A47 North Tuddenham to Easton

Scheme Number: TR010038

Volume 9 **9.31 Applicant's Responses to Deadline 7** **Comments**

**9.31 APPLICANT'S RESPONSE TO THIRD PARTY COMMENTS
AT DEADLINE 7**

# PROPOSED WOOD LANE JUNCTION

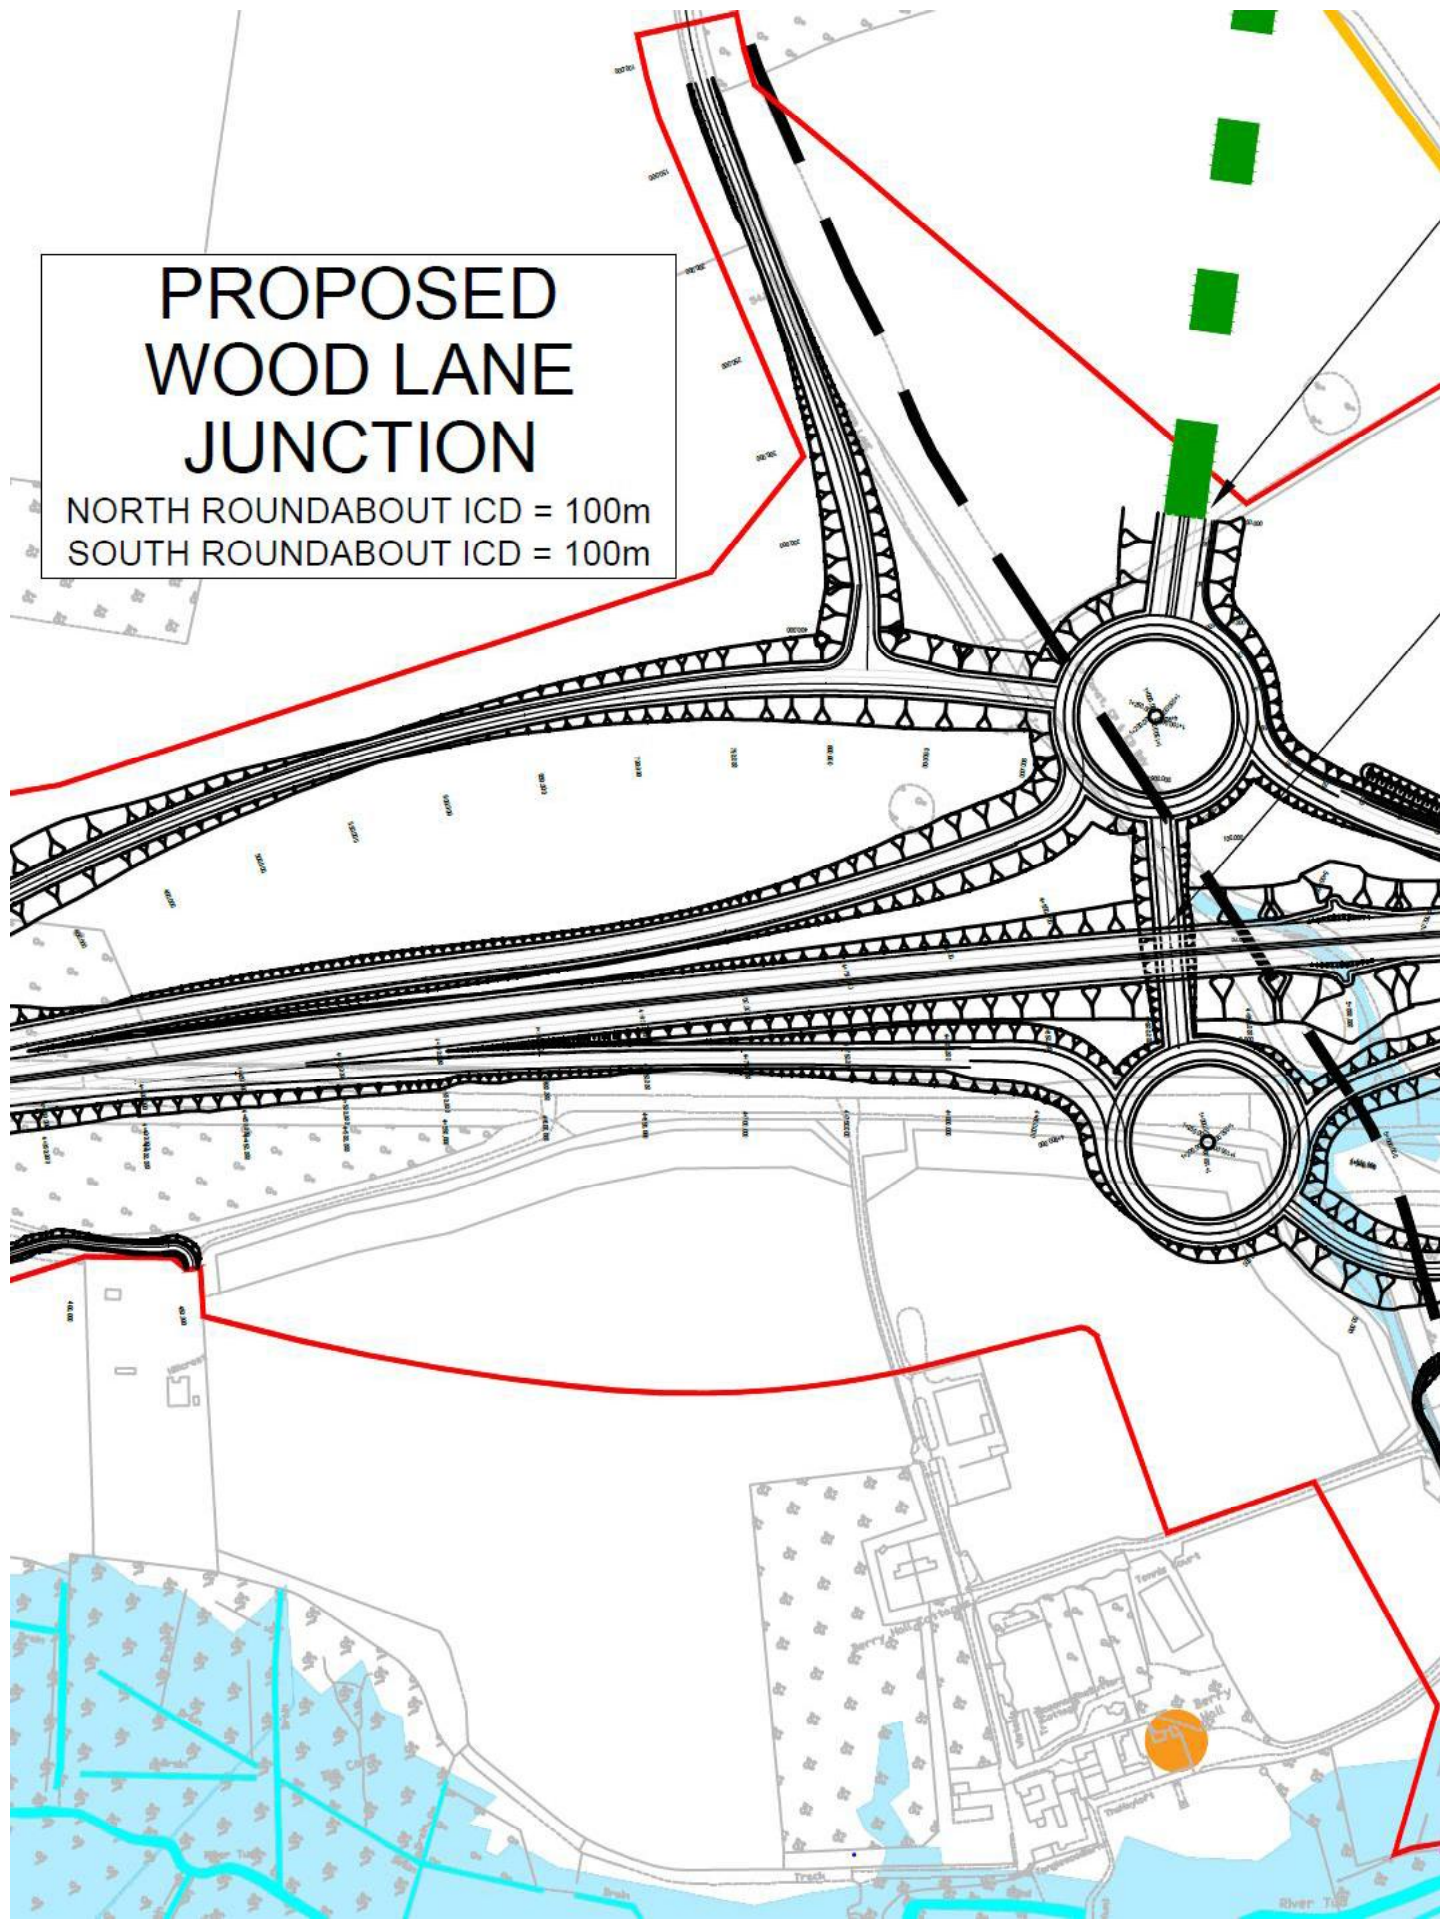
Comment	Applicant Response
<p>(REP7-023) / 11.</p> <p>Further, it is clear from the documents extracted in Appendix C that there are three critical parts of a junction for its safety and resilience, namely (1) entry width (2) approach width and (3) flare length. These are the three most important factors when determining a junction's form using the ARCADY software, while the remaining geometries (including ICD) have lesser effects (see App C, TRL RR142, para 4). The Applicant here is seeking to fix the ICD without having yet designed the three most important factors for all entries and exits to the junction (see the junction drawings which do not include these for the link road, the B1535 (Wood Lane), or the de-trunked A47), which it has confirmed to ACM will be done after the DCO is completed. In ACM's submission this places the cart before the horse and ACM invites the Examining Authority to require the Applicant to complete an indicative design which enables the roundabouts' size to be more robustly determined. It is also recommended in the manuals that the ICD size should take account of the landscape around it.</p>	<p>The Applicant has previously confirmed to Mr Meynell and his advisors at a meeting held on 11 August 2021 that all roundabouts had been proportionally designed in 3D with simple connections, however they were designed in 2D to ensure that entry width, approach width, flaring and deflection were provided / achieved in accordance with the UK DMRB.</p> <p>This information is a prerequisite for the ARCADY assessment for the Operational Modelling Assessment which is presented in Section 4.10 of the Case for the Scheme (APP-140).</p> <p>The Applicant used this 2D information to inform the "Highway Work Limit of Deviation" as shown on the Works Plans, Rev.2, Sheet 9 of 23 (AS-028). The below snapshot provides an overview of the preliminary design of the southern roundabout earthworks only with full 3D geometry design. The blue line shown is the "Highway Work Limit of Deviation".</p> <p>The design would be further developed during the detailed design stage and approved by the Secretary of State through dDCO Requirement 3 following consultation with the relevant planning authority.</p> <p>Snapshot of Southern Wood Lane Roundabout:</p>

Figure 2-3: Wood Lane Junction Alternative 1

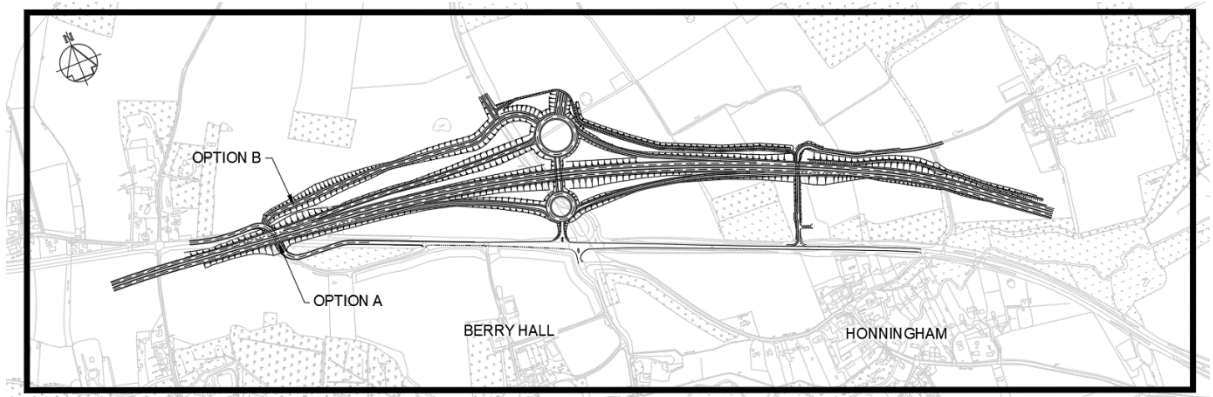
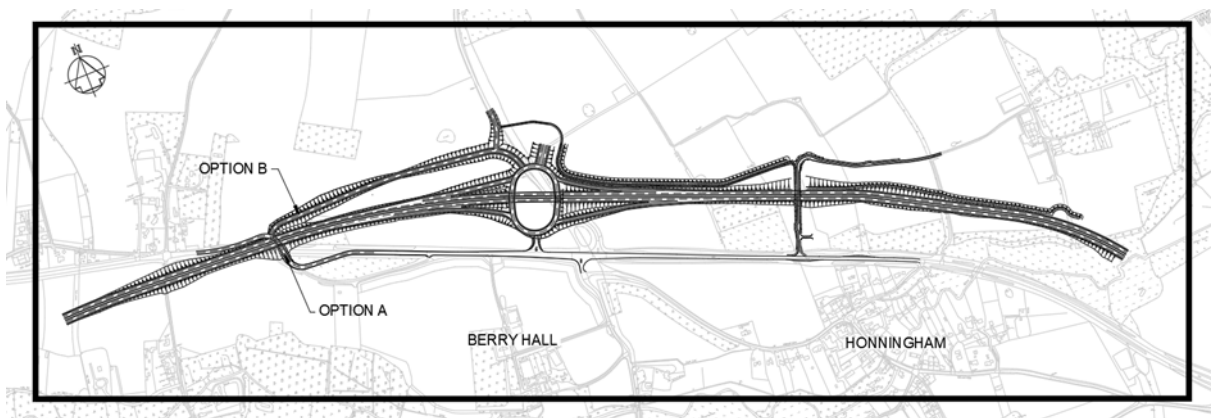
<p>(REP7-023) / Appendix D: Contains three photographs of existing grade separated junctions constructed by the Applicant on trunk roads Overlays on the Applicant's satellite view of the south dumbbell of the Wood Lane Junction (REP6-018 pdf page 17/37) illustrating the land taken by the suggested reduction of its inscribed Circle Diameter (ICD) to the 80m suggested by the Applicant at REP6-018 and to 70m as illustrations of the reductions which could have been considered following the suggestions on behalf of ACM by Mr Foster in his initial report with ACM's WRs (REP1-057, para 14.3).</p>	<p>Appendix D does not assist the Examination, as there is no evidential benefit in images of random junctions across the SRN network out of context.</p> <p>The Scheme has been designed to take into account the Scheme objectives and traffic modelling as presented within the Scheme Design Report, Rev.1 (AS-009) and the Case for the Scheme (APP-140).</p>
